Your Ref: 000014168
Our Ref: FP/194/12/ 15-10-2012
Please ask for:
Miss K Rawlins

7th December 2012

Change of use from office (A2 Financial & Professional Services) to residential (C3 Dwelling Houses)
119 Felpham Way Felpham

Site and Block Plan

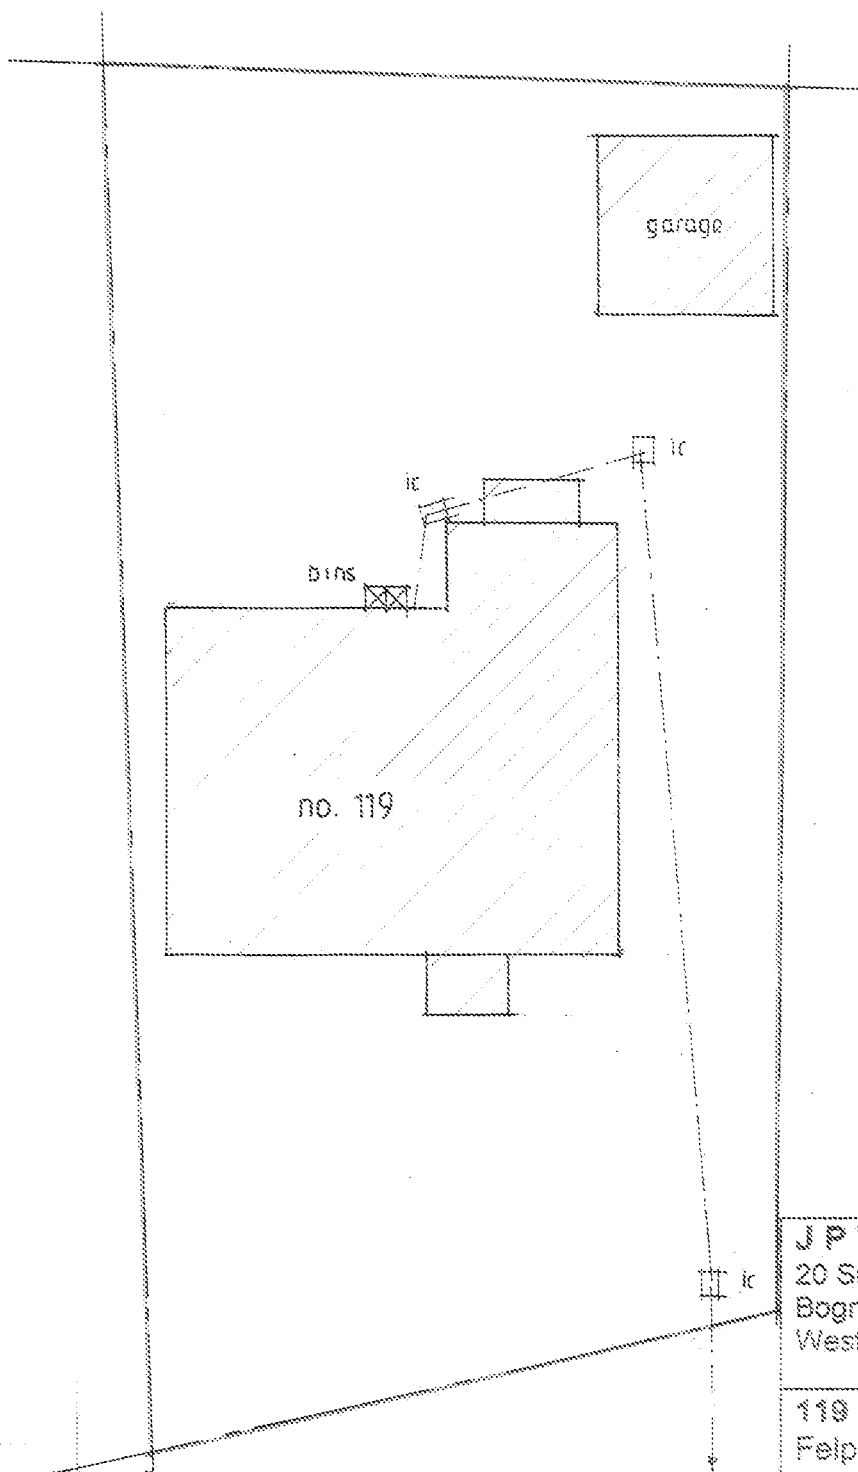
As part of this, however, we request that any permission granted is conditional on a new or repaired fence and wall being provided along the western boundary of the site (between our property and 119) as the current one is currently in poor repair and provides poor security, particularly between back gardens. Furthermore, we would want the opportunity to comment on and agree any chosen style/design/type for this prior to it being erected.

One further point to raise is that the red edging shown around the plot on one of the application plans is incorrect, extending too far north. It should be amended to accurately reflect the plot as it is now.
